Memorandum

Re: Cottonwood Crossing Car Wash Site Plan Comment Responses (PR-2021-005816)

This memo outlines the responses and changes made to the Cottonwood Crossing site plan amendment for development of a car wash at 10084 Coors Boulevard NE based on comments reviewed at the December 15, 2021 DRB meeting.

- KEY NOTES:
- PROPERTY BOUNDARY
 - EXISTING LANDSCAPE ISLANDS, 2
 - CONNECTION TO PUBLIC SIDEWALK
 - 11' SITE TRIANGLE
 - STRIPING

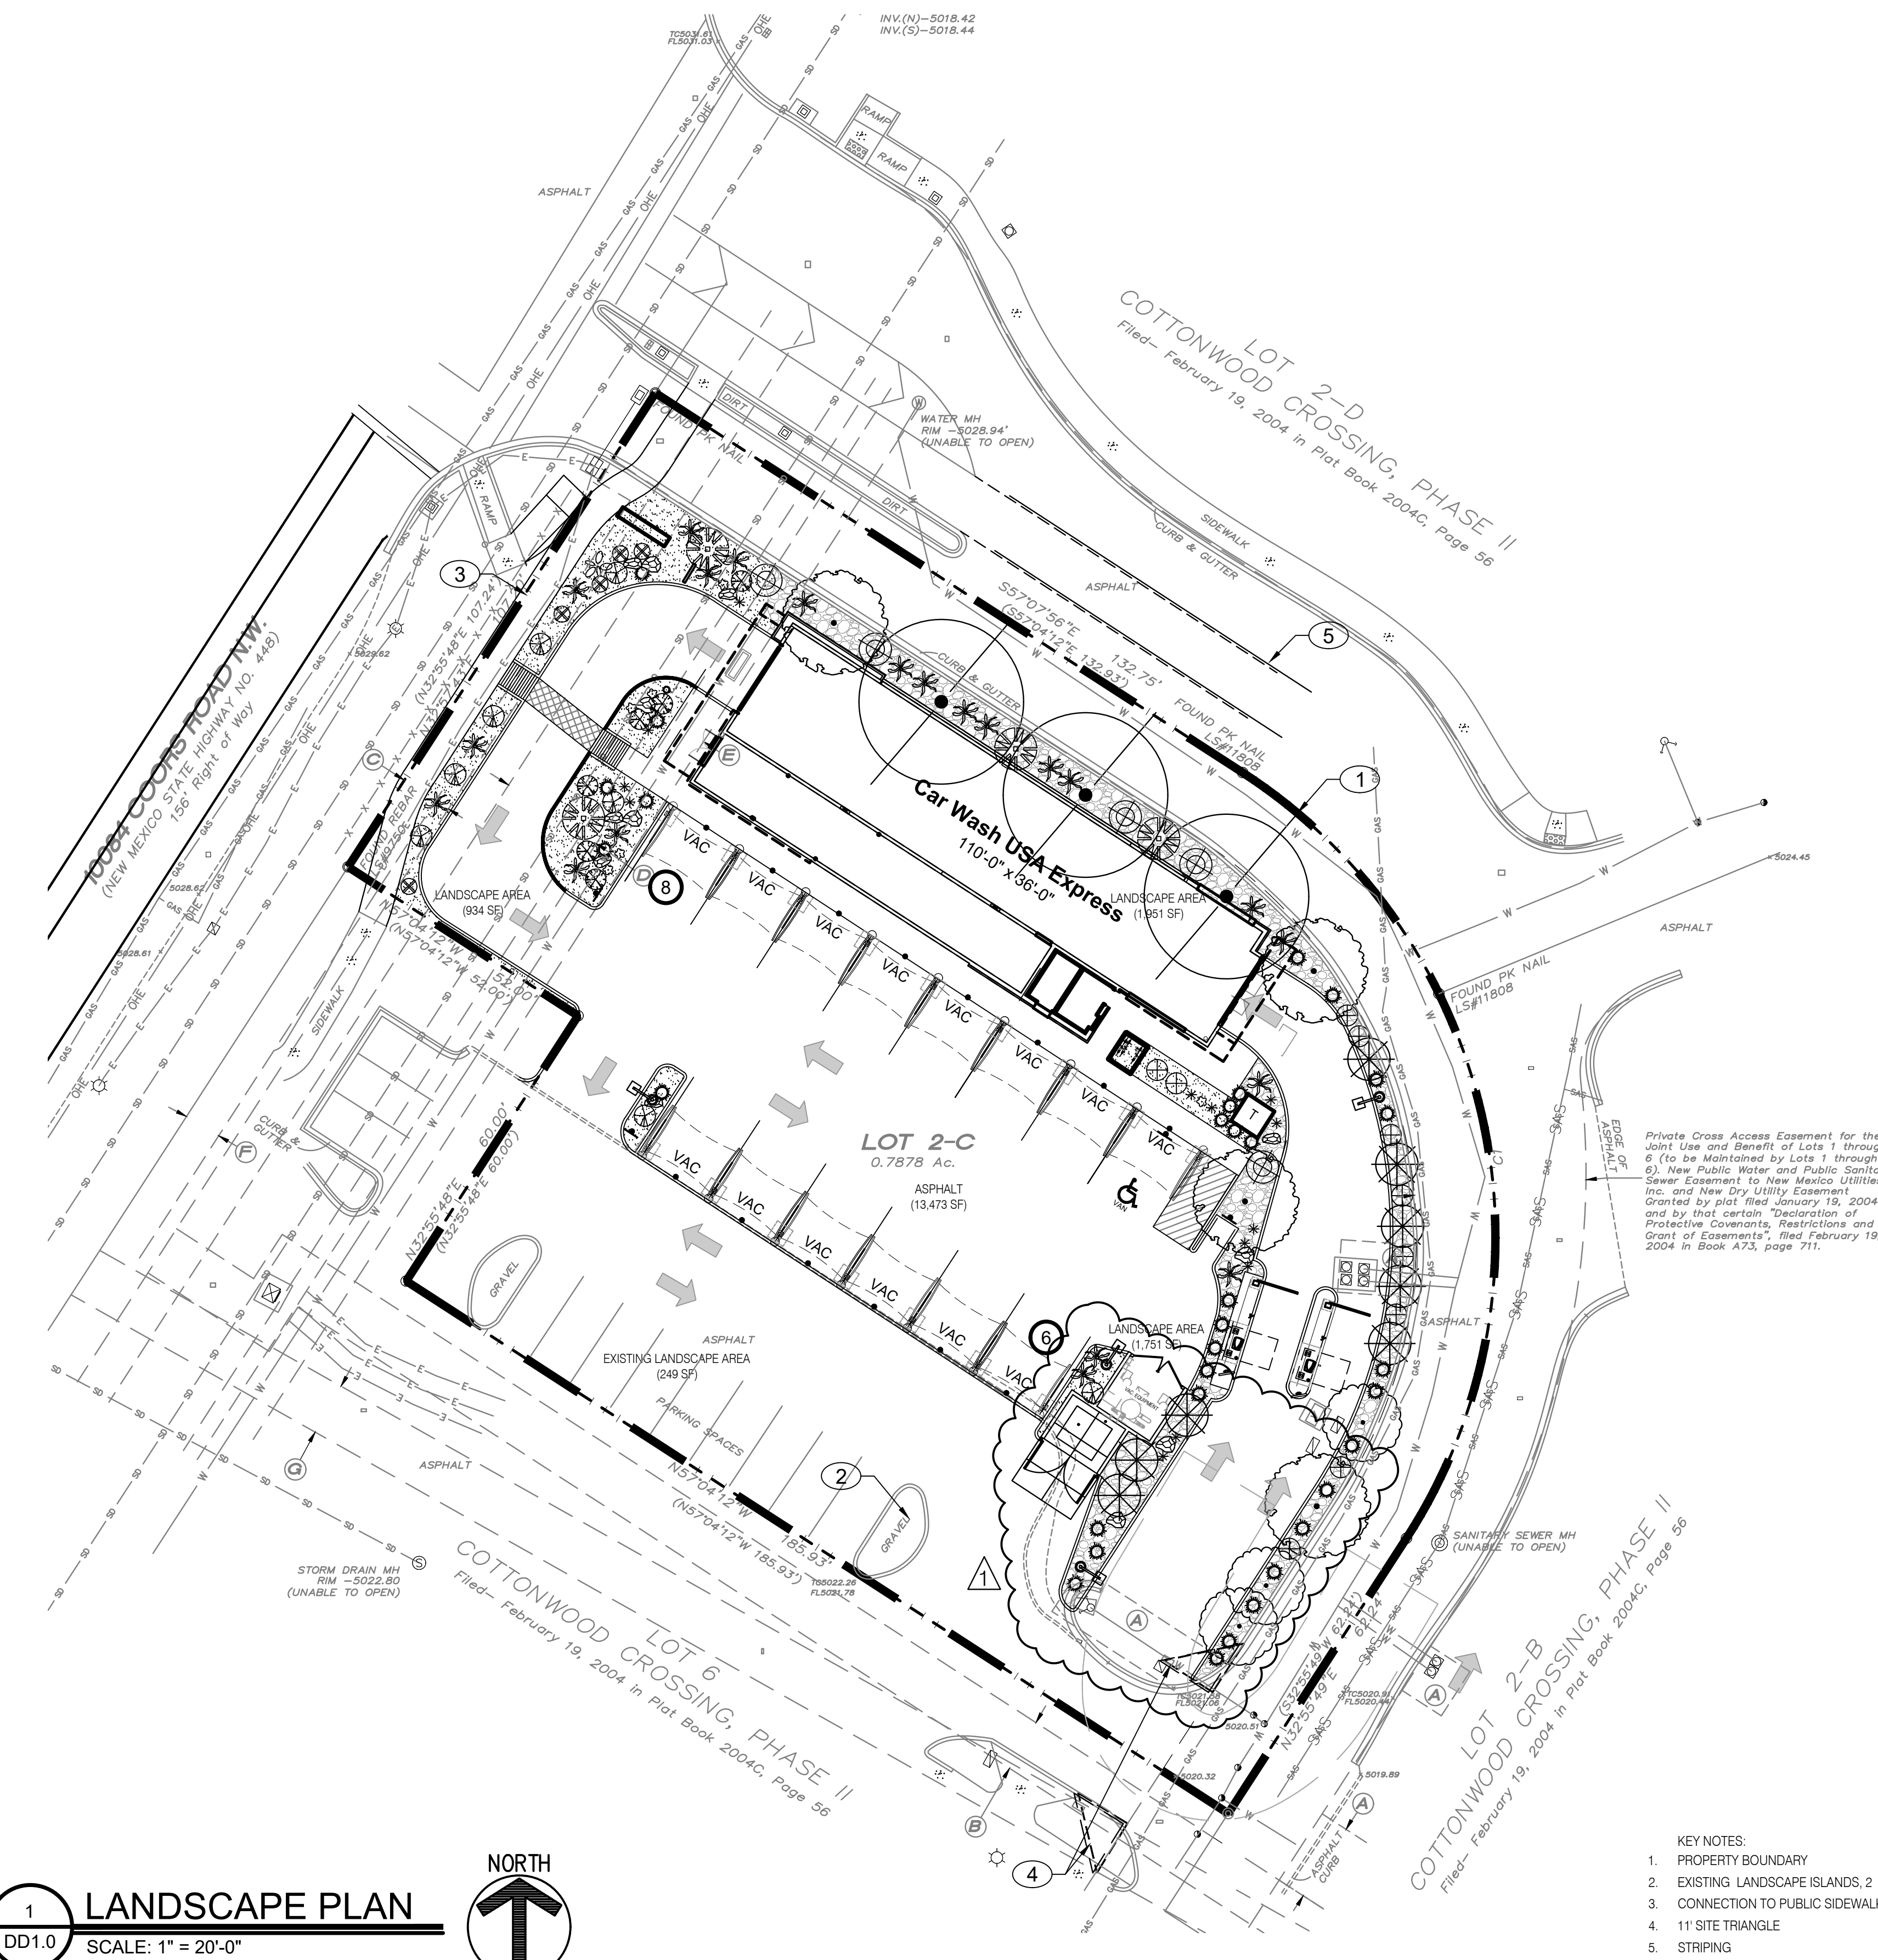
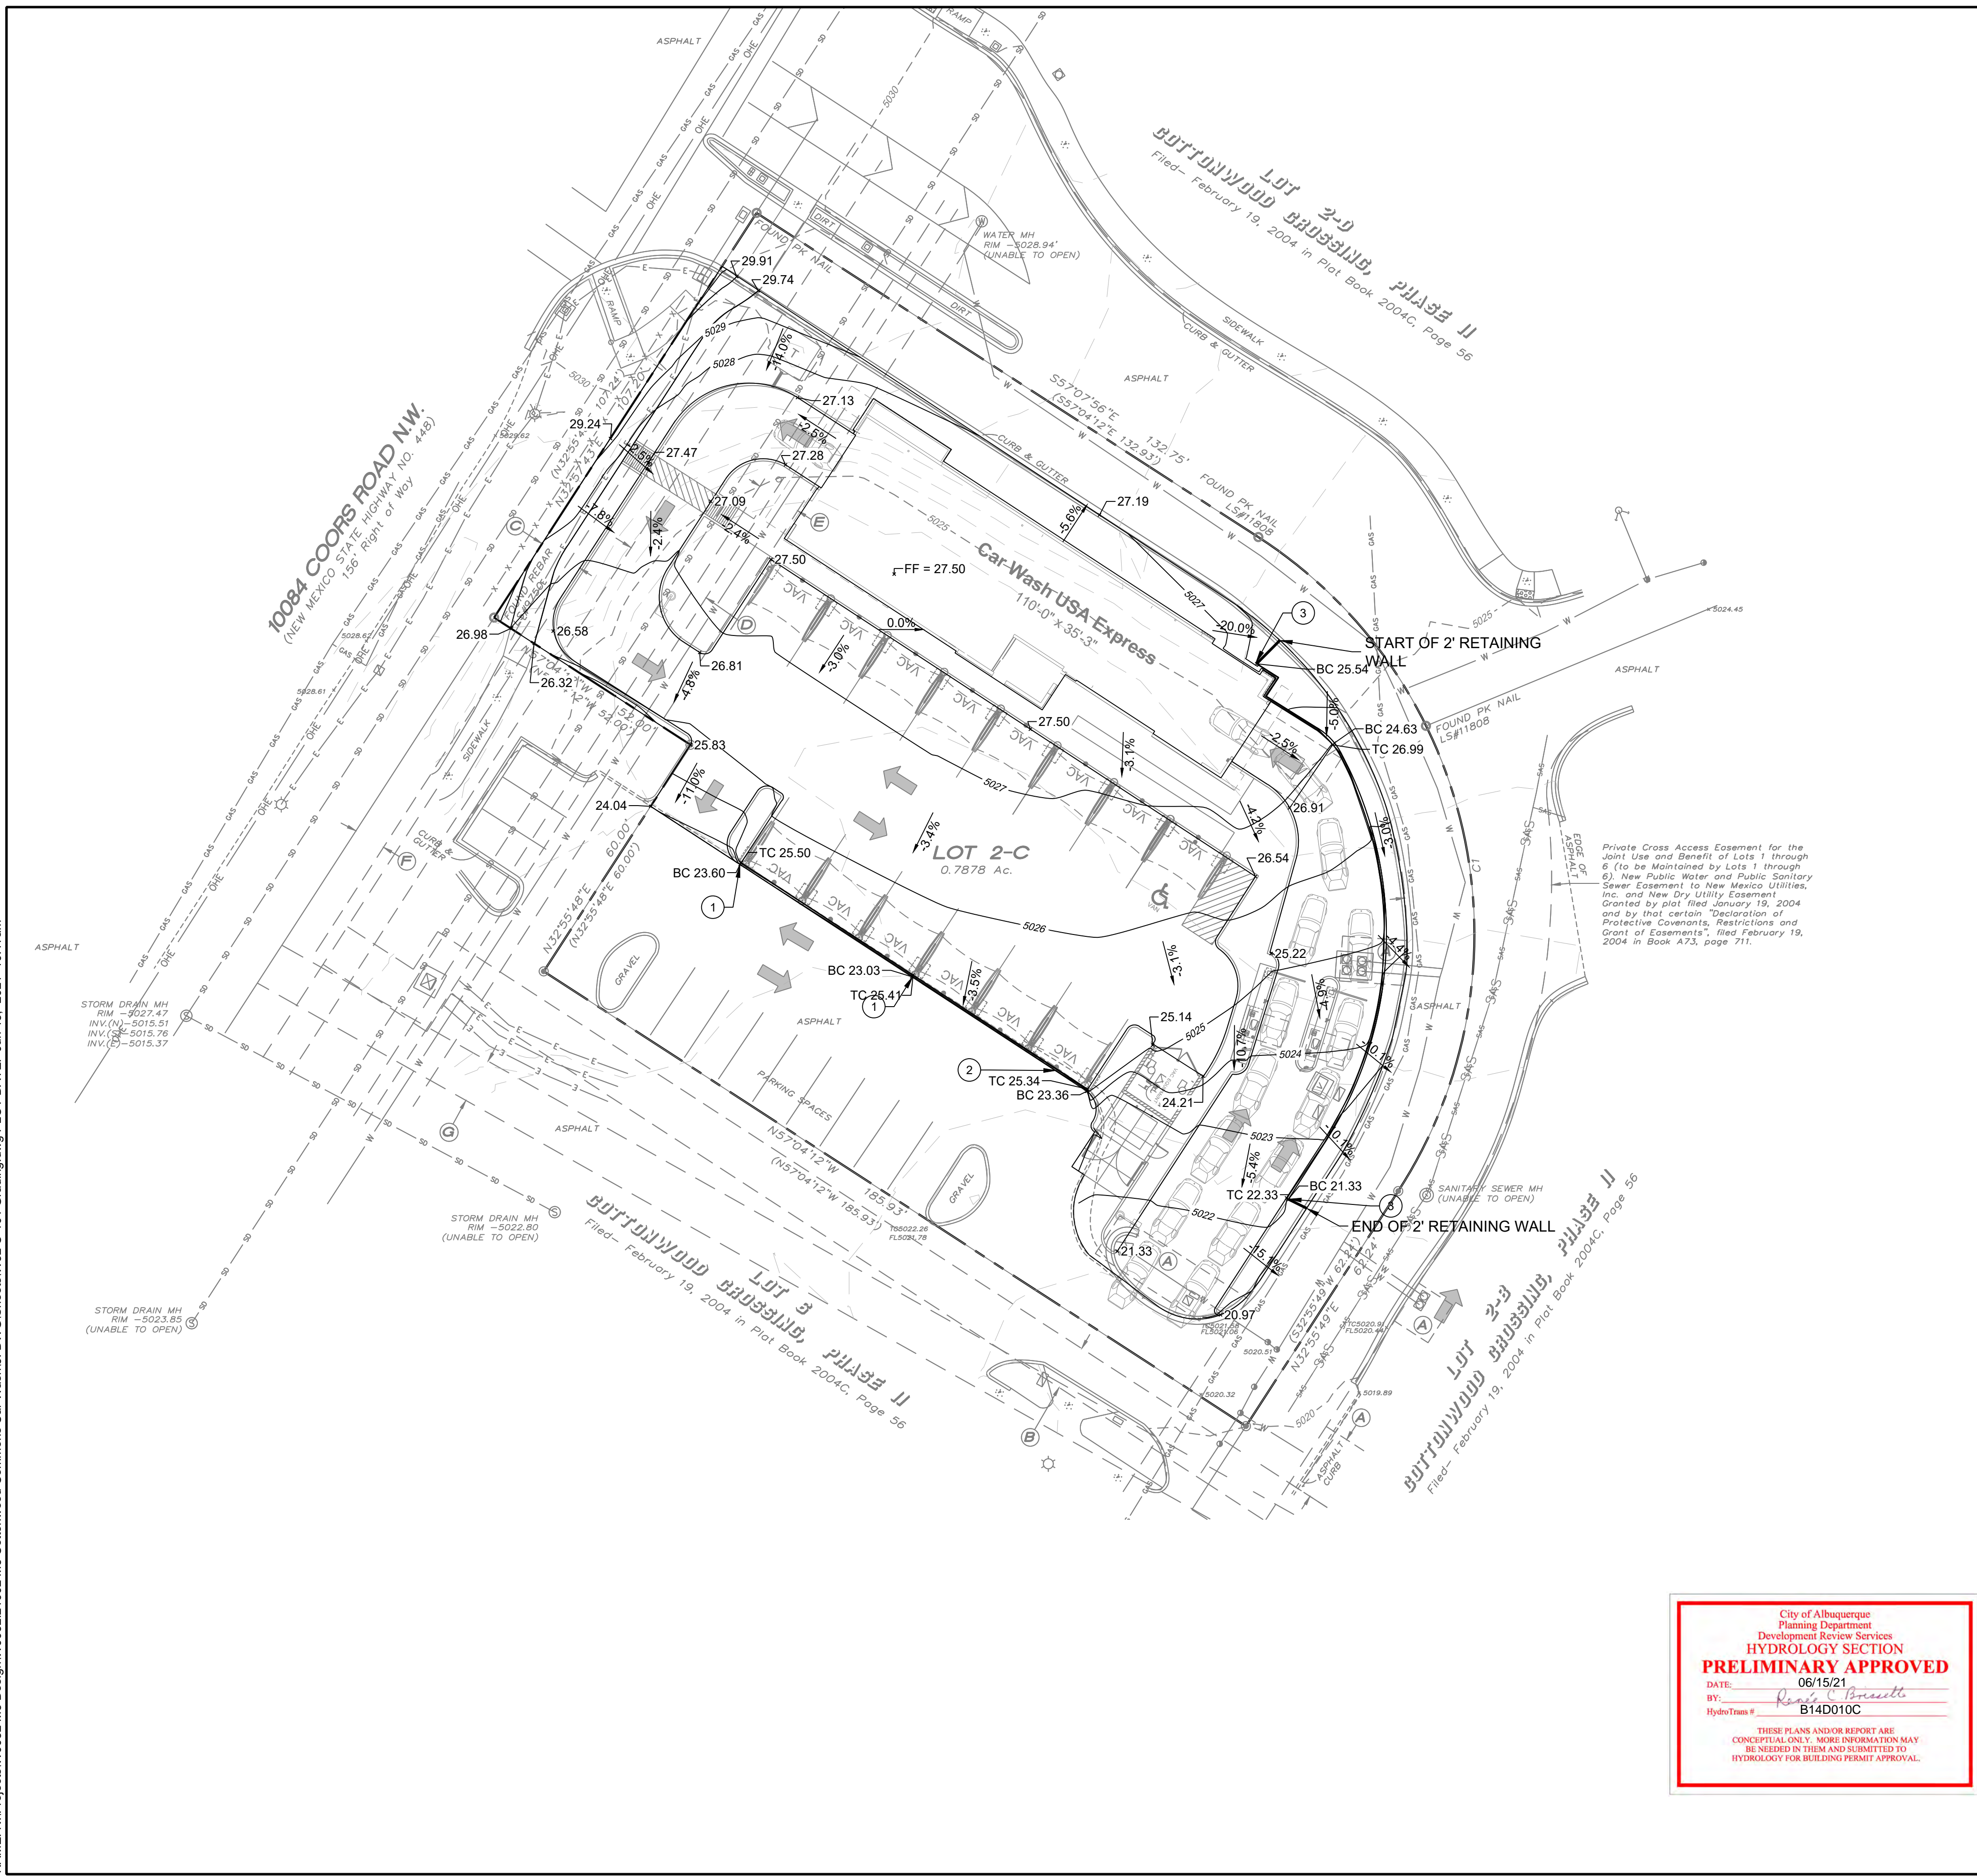
2. The application and NOD discuss neighborhood comments requesting an upgrade to the landscape buffer. This area is clouded on the Landscape Plan. Is this the final version?
The landscape plan presented is the final version, which includes additional trees along the east side of the site along the stacking lanes that was not originally proposed.

3. The Parks and Recreation Department (PRD) is a partner with the Nature Conservancy who developed a Climate Ready Tree List for Albuquerque. Please swap out trees that are not on the

list, and higher water use, with trees that are on the Climate Ready list (here: NMFO Climate-Ready Trees Lists (nature.org)). Raywood Ash is not on the Climate Ready list - please comment if this tree is chosen because landscape buffer areas are intended to be water quality swales.

4. In addition, Trees must be recommended by the Official Albuquerque Plant Palette: Official Albuquerque Plant Palette and Sizing List-2018-07-03.xlsx (cabq.gov) per IDO Section 14-16-5-6(C)(4)(b).

The Raywood Ash have been replaced on the updated landscape plan.
